DRB Application No.: 07DRB-70251 (SBP) Project # 1006832

Project Name: FOUNTAIN HILLS PLAZA SUBDIVISION

RE: Fountain Hills Plaza/spbp

TO: Sheran Matson, DRB Chair
FROM: Carmen Marrone, Senior Planner
RE: **Project #1006832, Fountain Hills**

**SHEET NUMBER**  
**A-201**

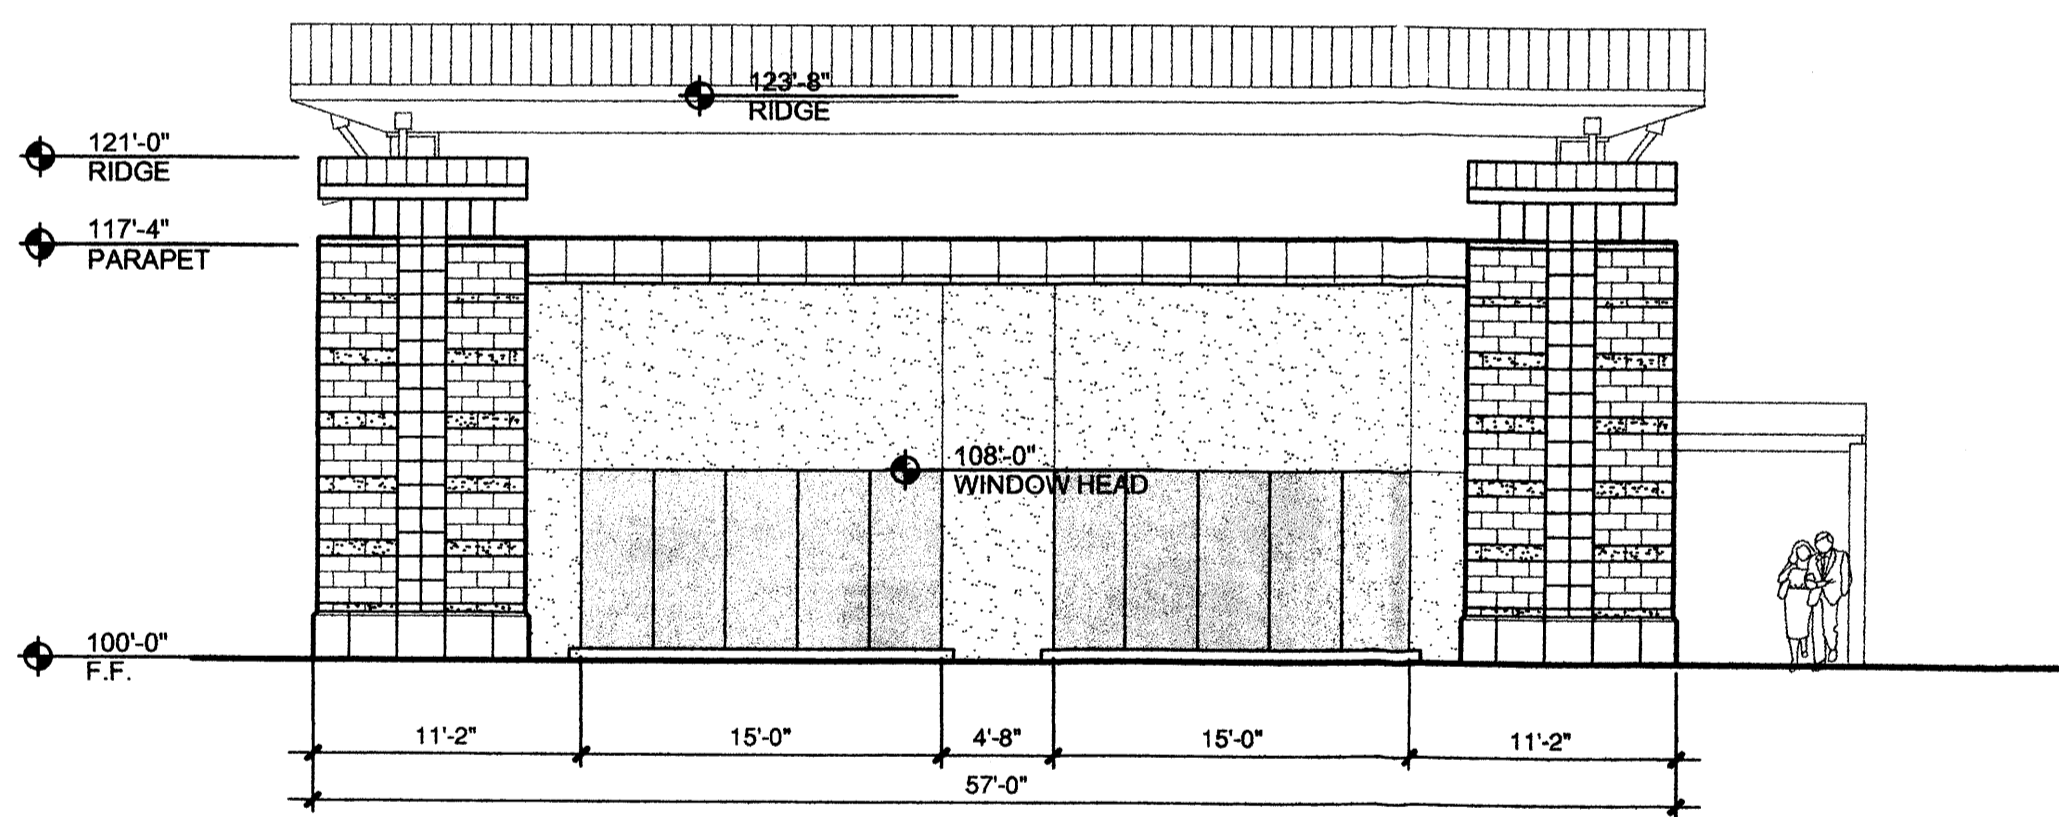
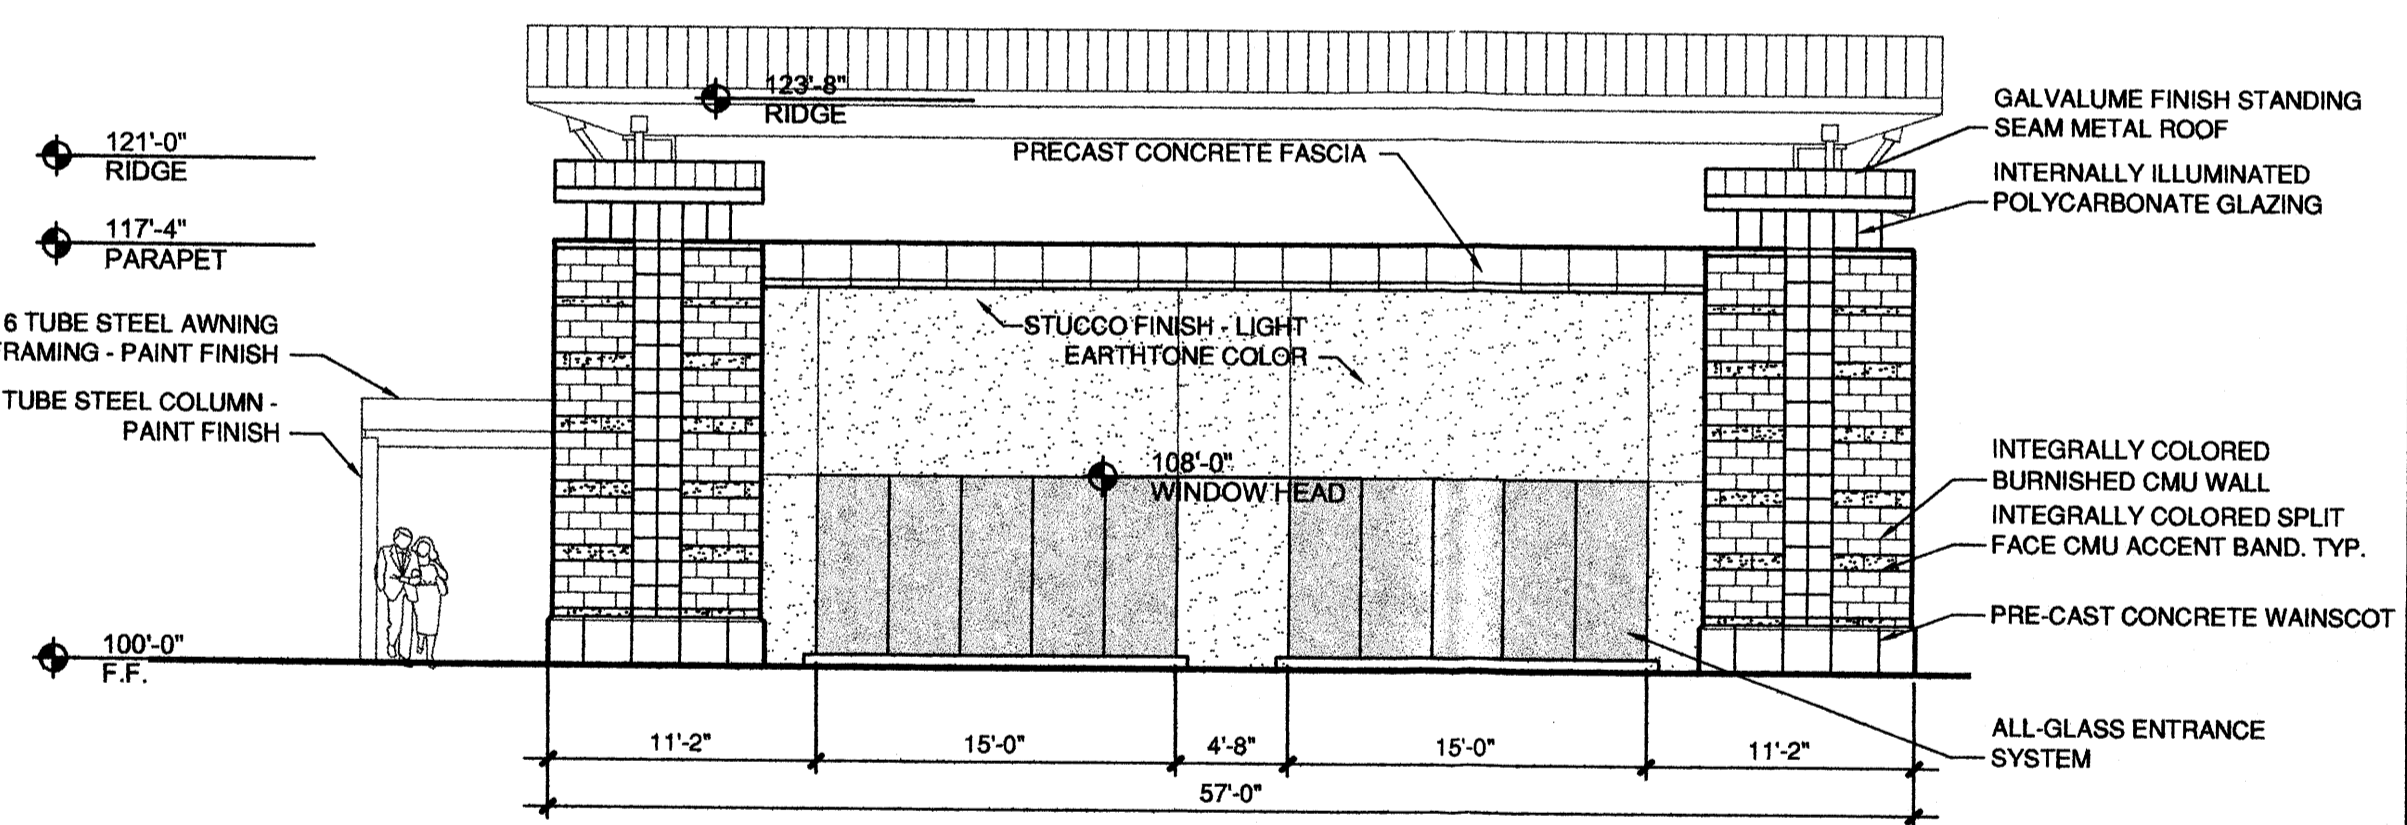
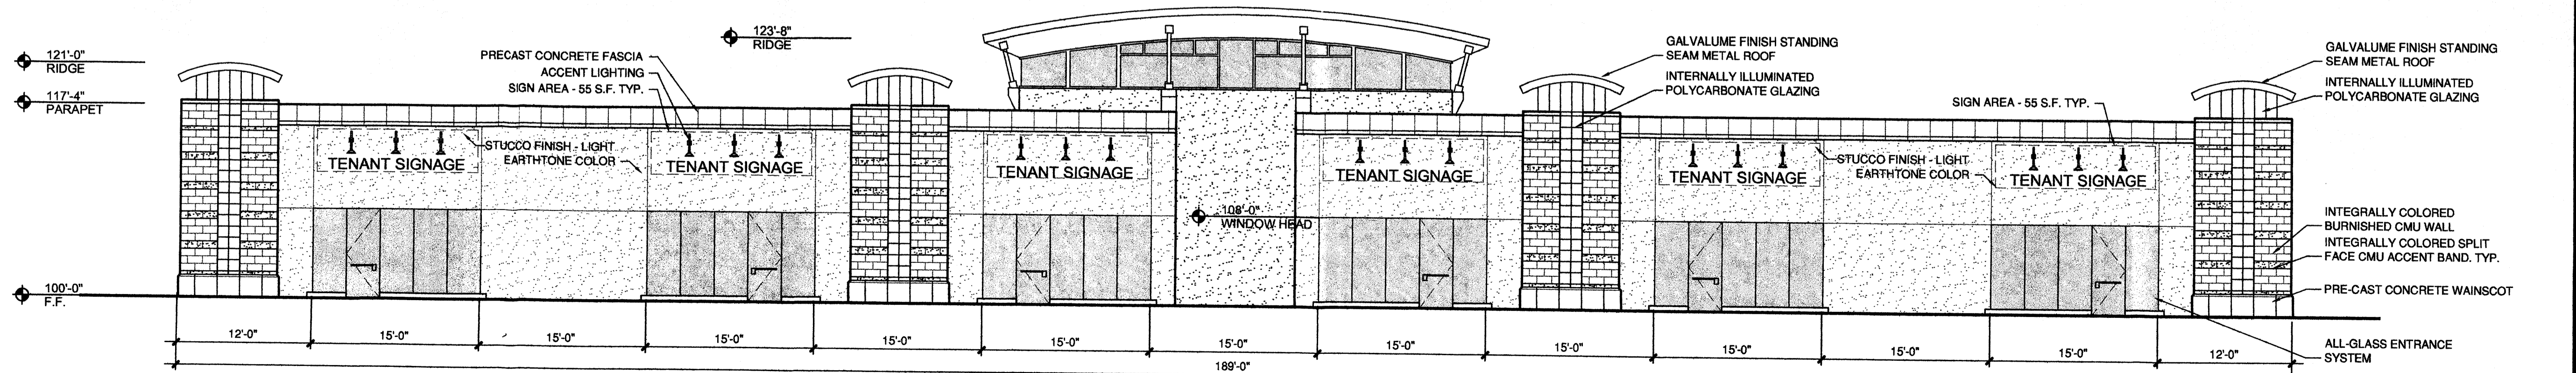
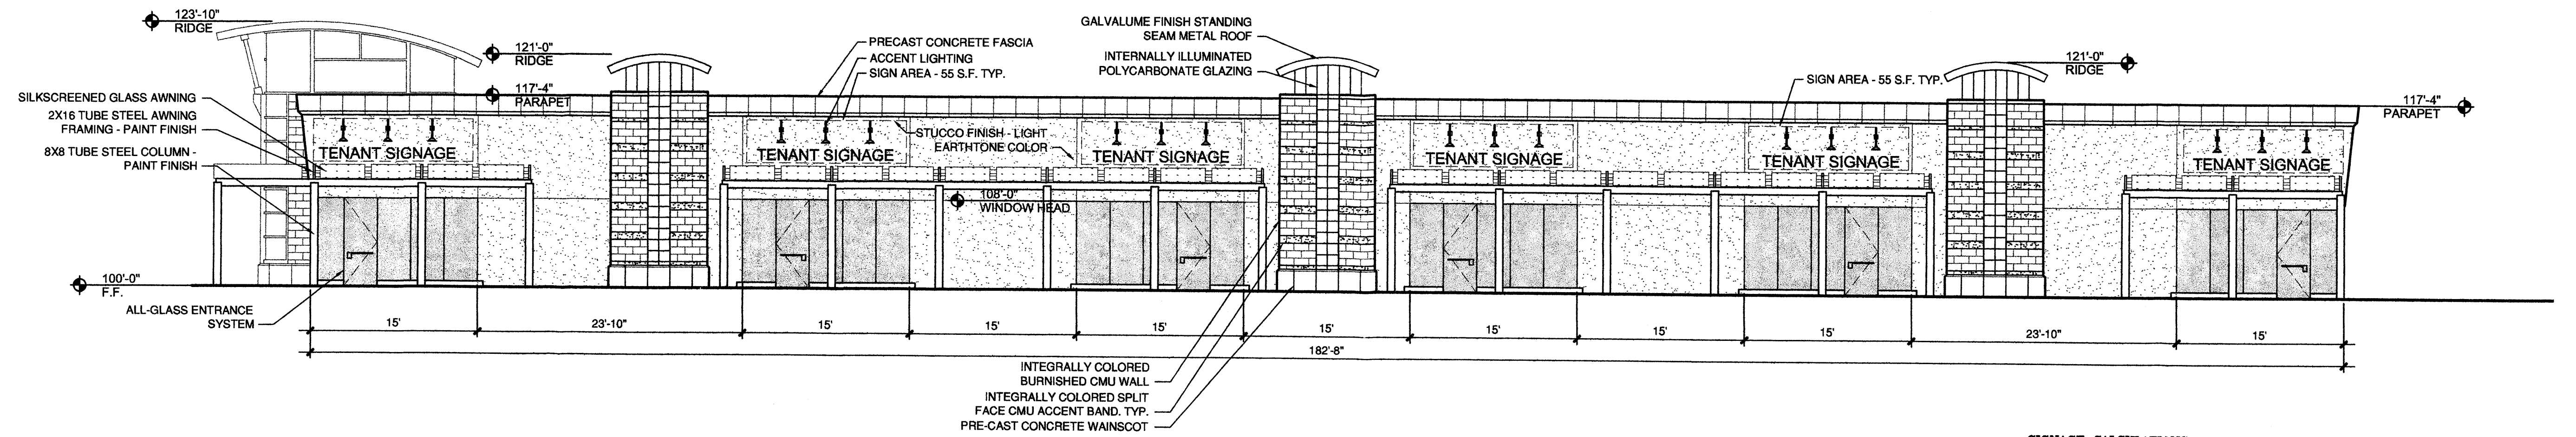
1. The elevations need more specific colors. Instead of "earth tones", for example, say "medium tan".
2. Remove the junipers from the landscape plan.
3. Label on the site plan sheet where the wall is located. Assuming the wall is visible from the street, the wall regulations in the Zone Code allow a maximum of 50% plain CMU block, require a cap overhanging 2" minimum and pilasters every 20 feet or decorative columns every 60 feet, also projecting a minimum of 4" from the wall on the public side. The maximum height must also appear on the site plan sheet.
4. Finally, this plan has great pedestrian flow throughout the project.
